FINAL DRAINAGE REPORT
for
WINDERMERE FILING NO. 1

SF-21-026

**PCD-ENGINEERING REVIEW COMMENTS
IN BLUE BOXES WITH BLUE TEXT**

**EPC STORMWATER REVIEW COMMENTS ARE
SHOWN IN ORANGE BOXES WITH BLACK TEXT**

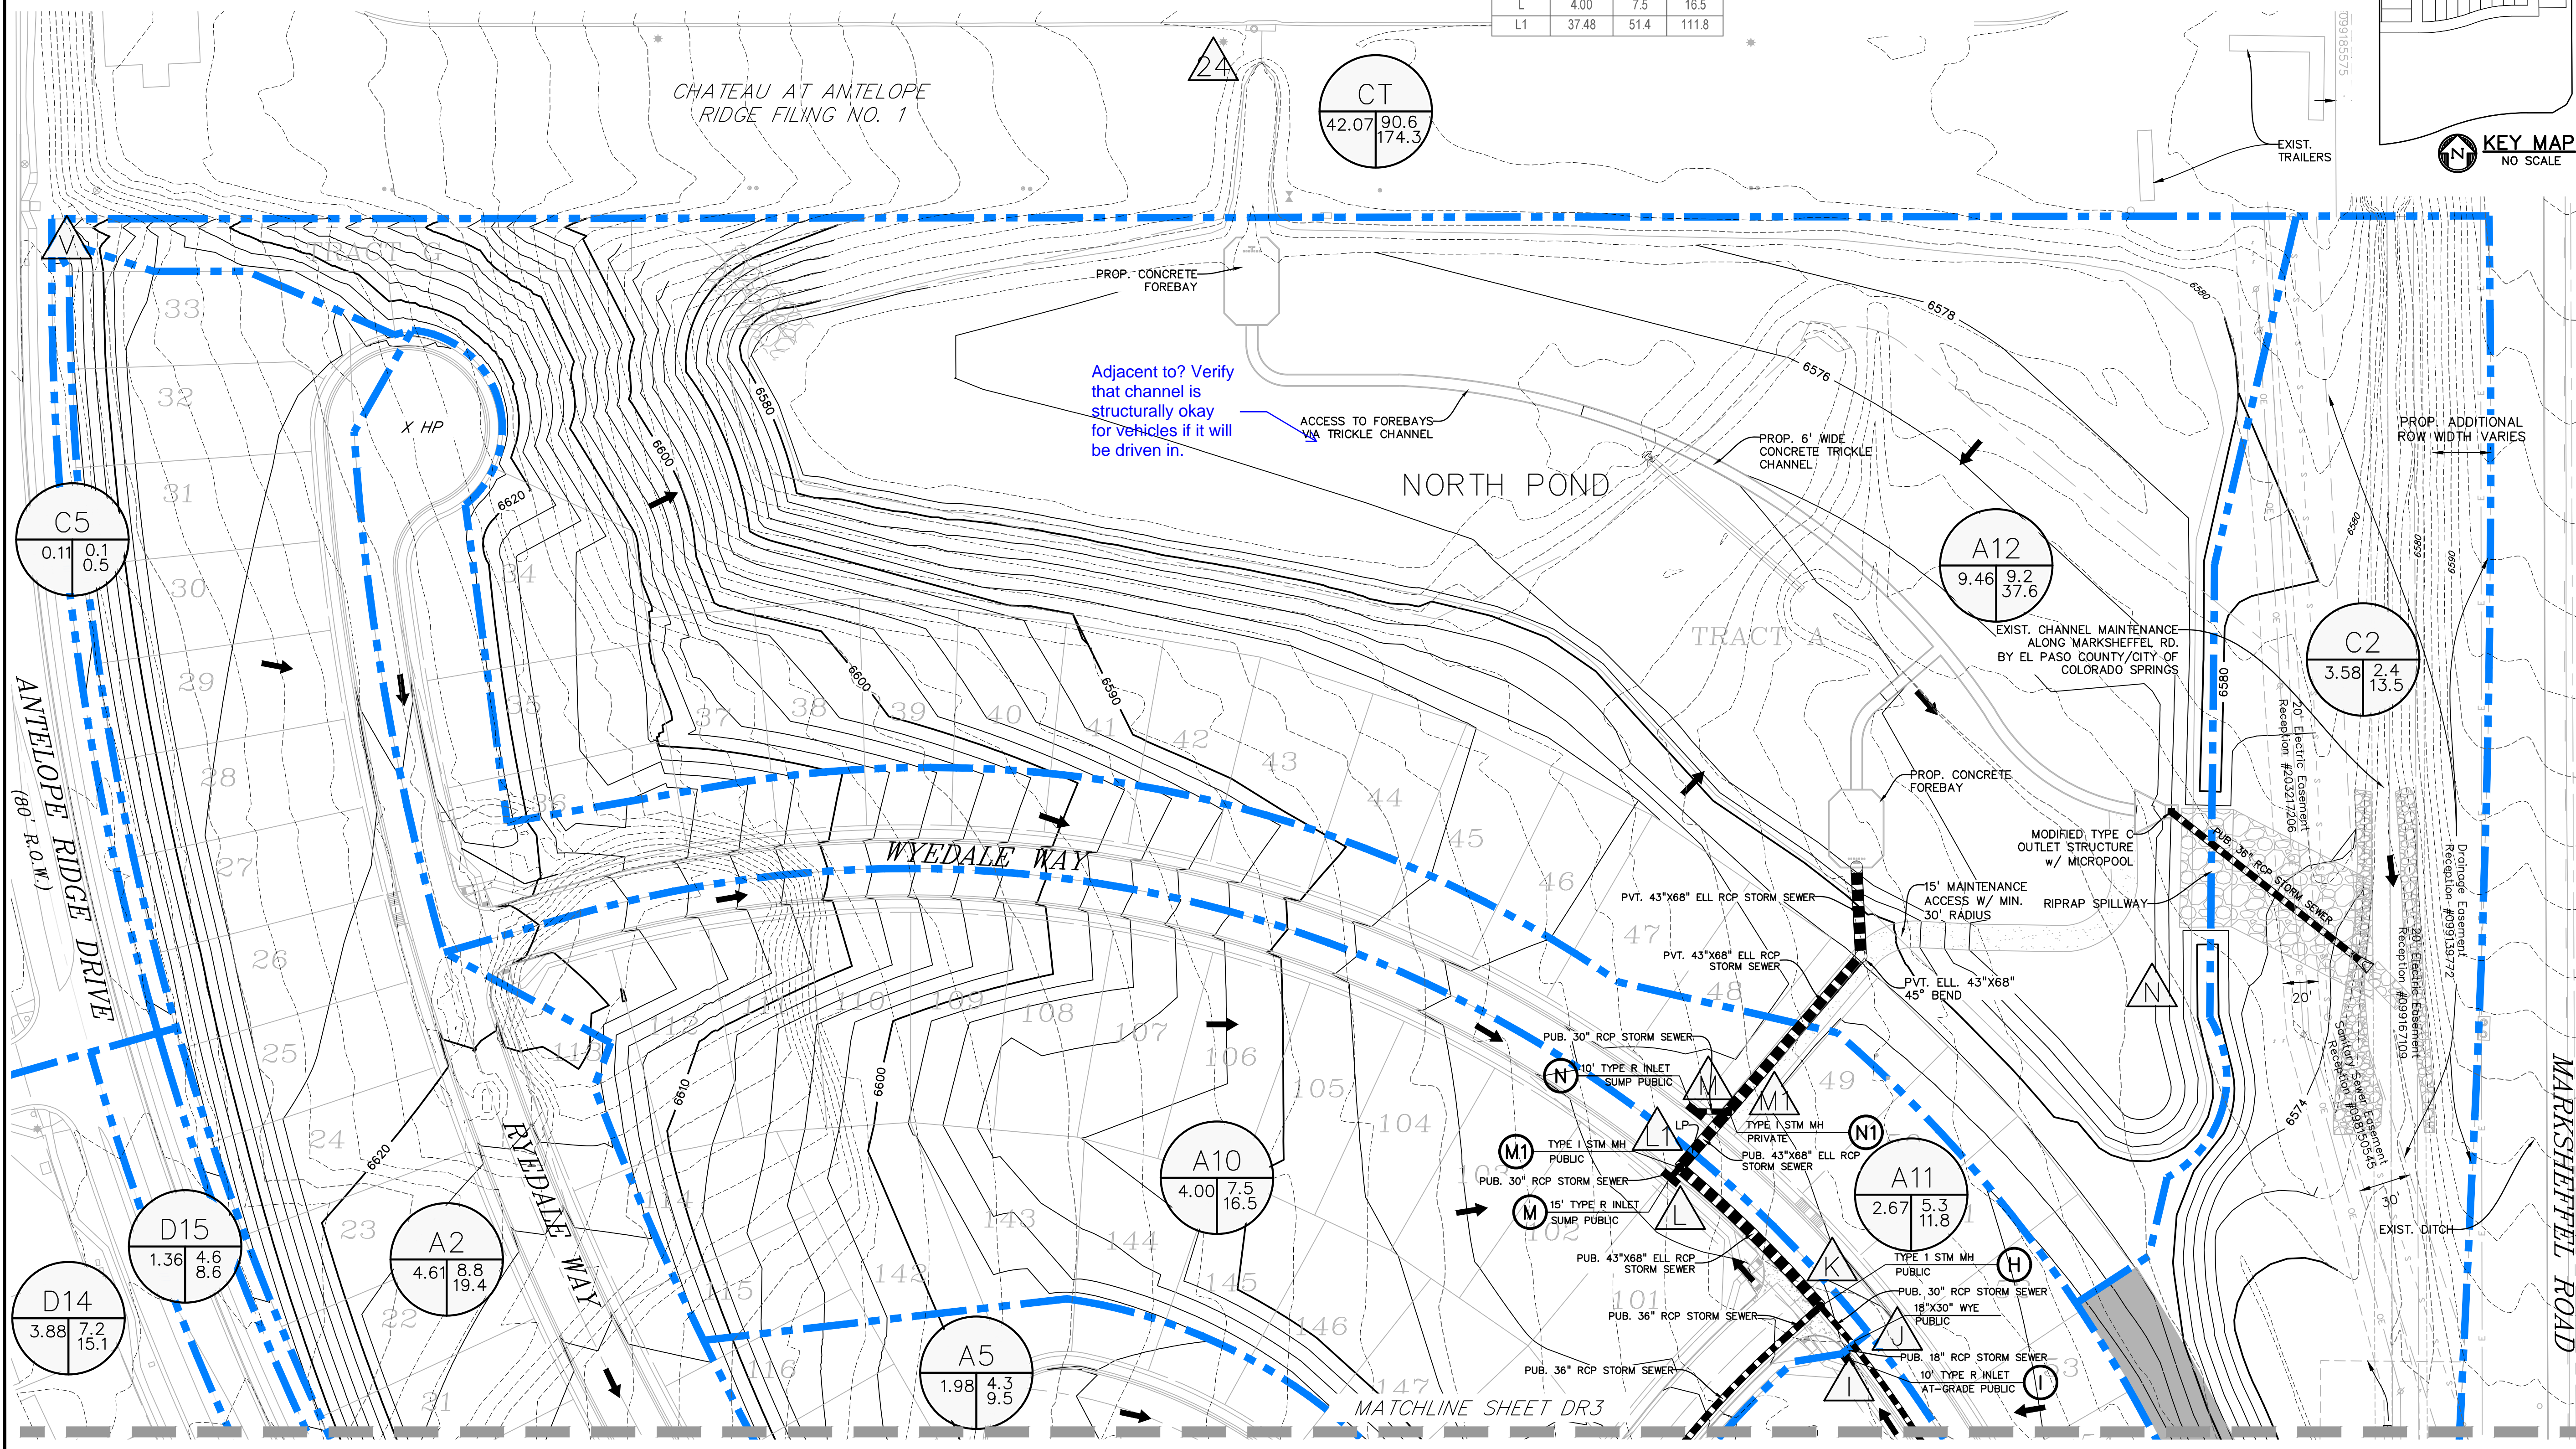
> 11 acres?

also provide detained flows

Provide a description of DP-7

This is not clear on the plans

discuss each area and provide a WQ area plan per comment memo

← Address the increase in runoff and conveyance to the north.
